REFUSAL OF PLANNING PERMISSION

APPLICATION NO. 2017/0994

Proposal Conversion of first and second floors in 27 residential apartments

At Hoyland Town Hall, High Street, Hoyland, Barnsley, S74 9AD

PROPOSED SECOND FLOOR PLAN
(SCALE 1:100)

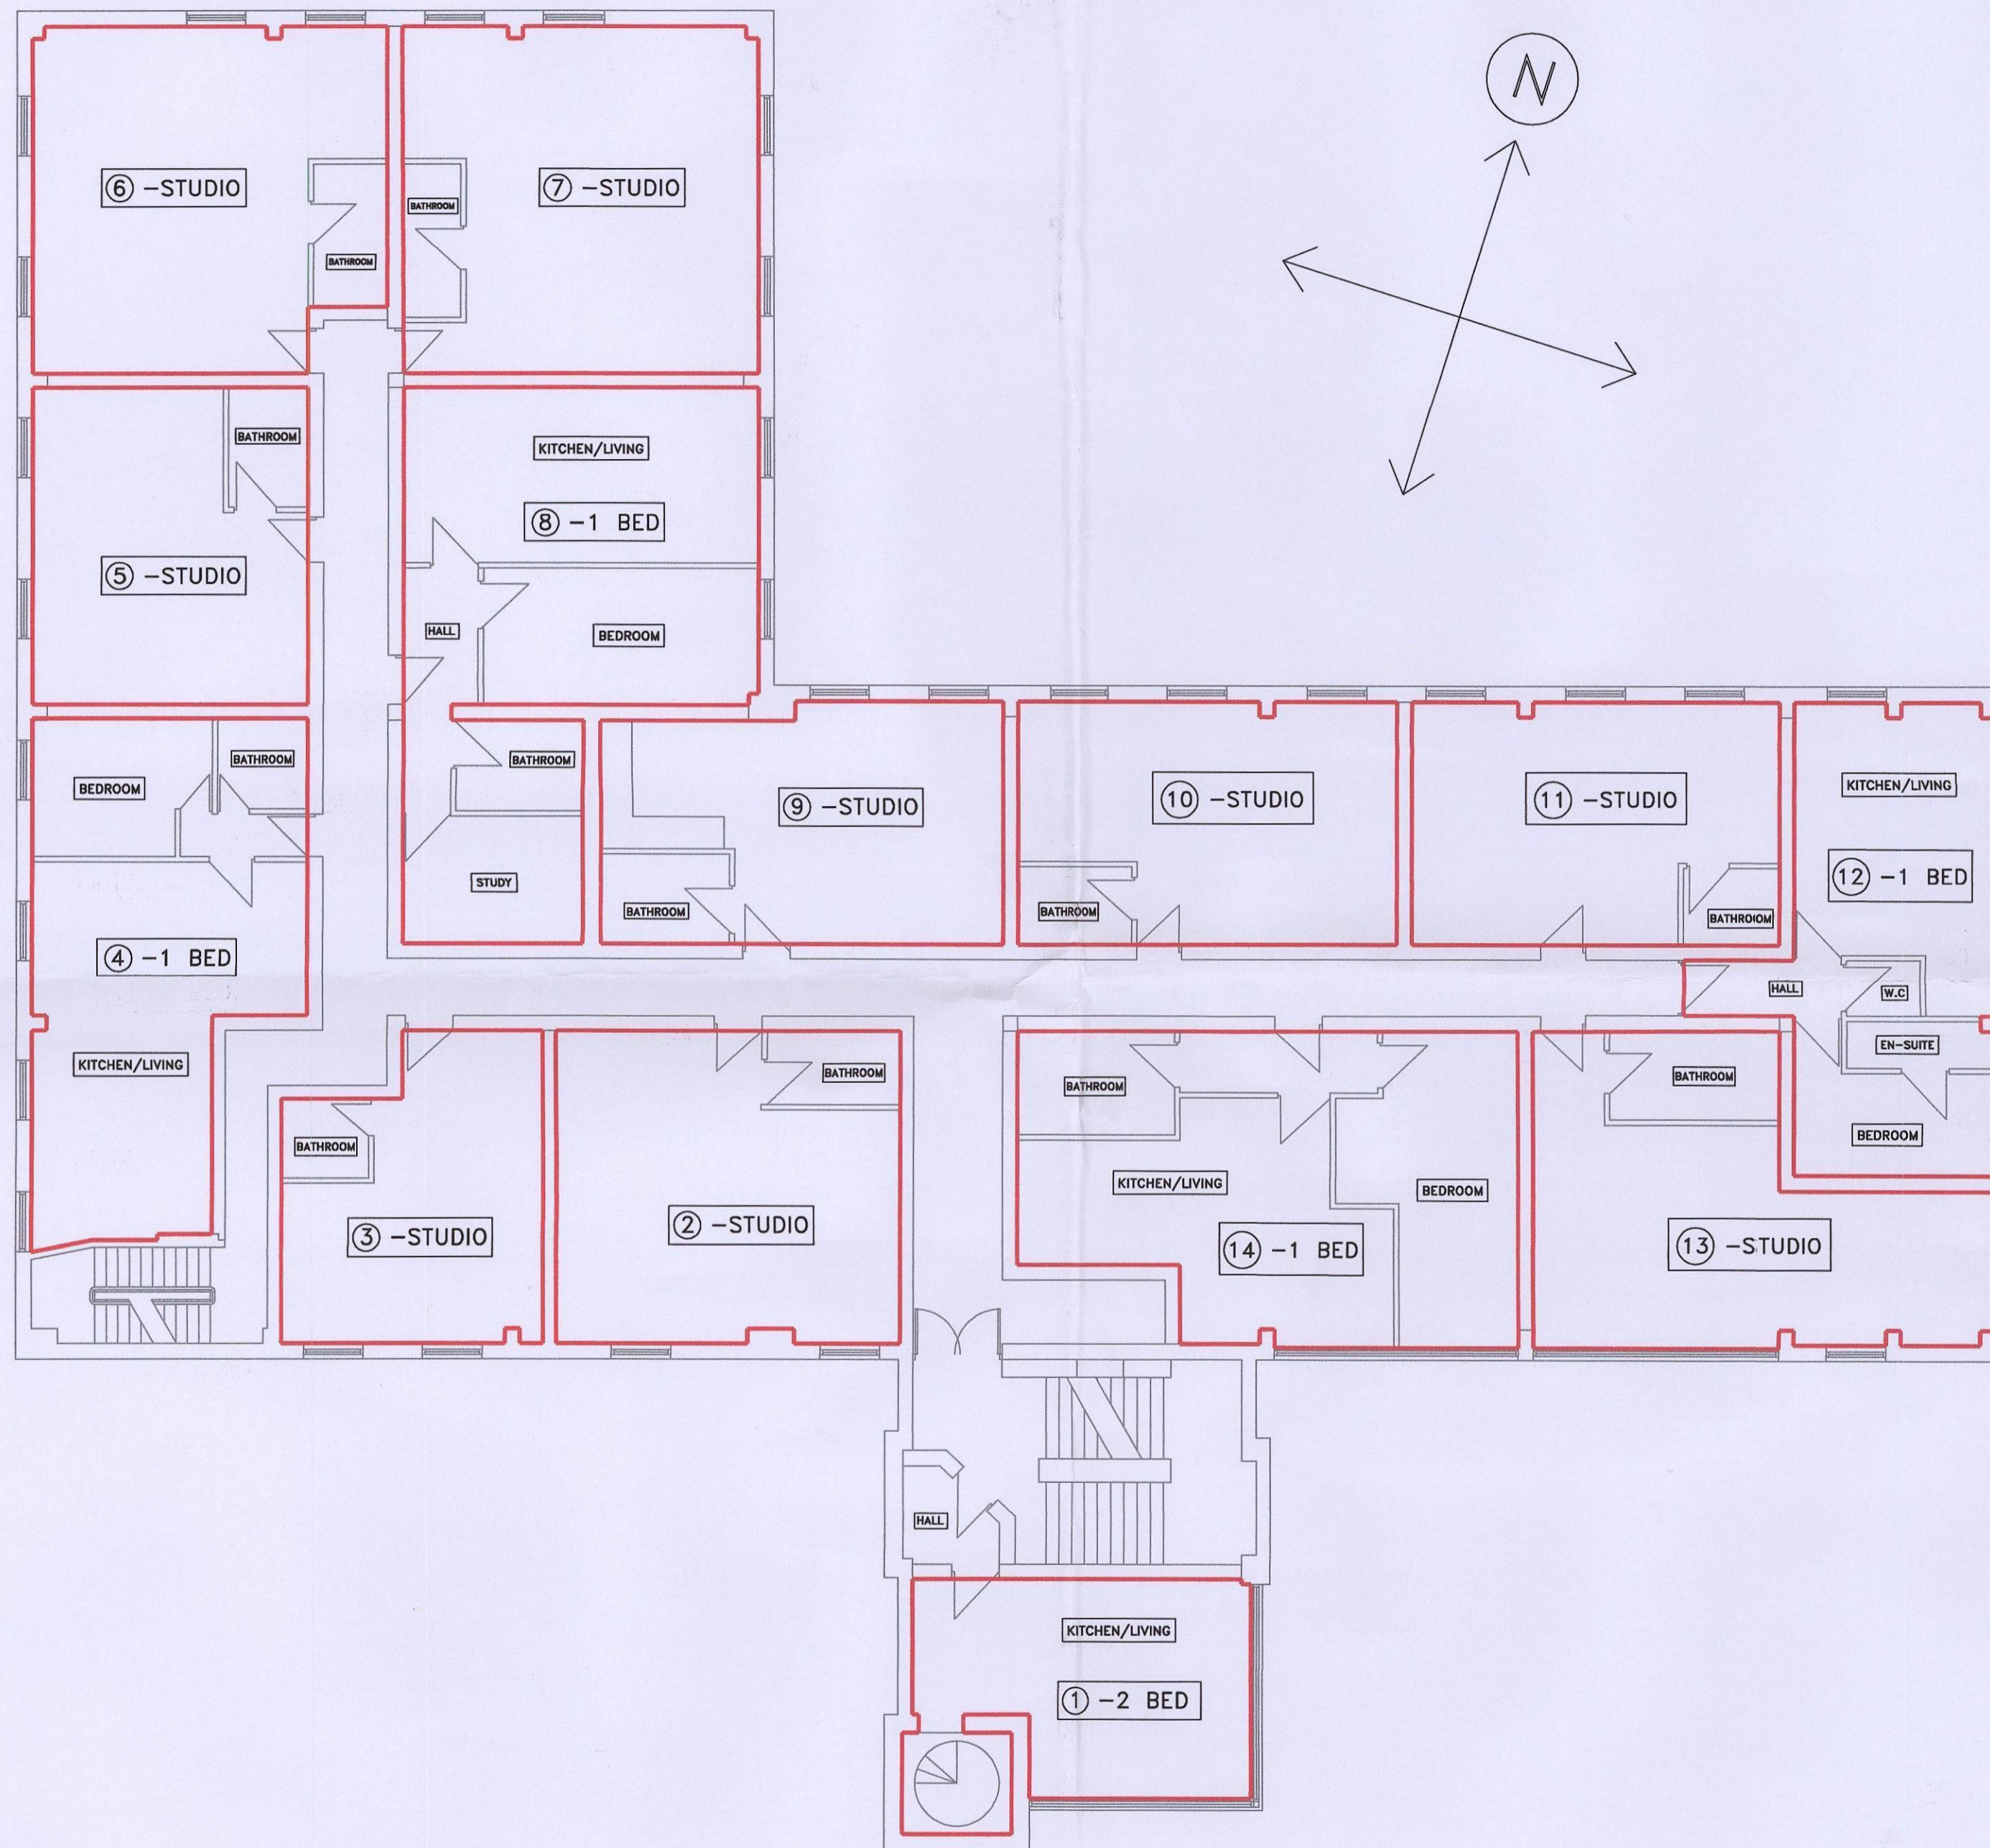
- 1 The development would provide substandard levels of amenity for occupants, provide an insufficient mix of unit types, including no "affordable housing" in accordance with policy requirements and would provide no other contributions to local infrastructure. As such, substantial weight is given to the harm identified which would significantly and demonstrably outweigh the benefits, due to the development being contrary to CSP 14 'Housing Mix and Efficient Use of Land', CSP 15 'Affordable Housing', CSP 40 'Pollution Control and Protection', SPD 'Designing New Housing Development, SPD 'Parking', SPD 'Open Space on New Housing Developments' and the South Yorkshire Residential Design Guide.
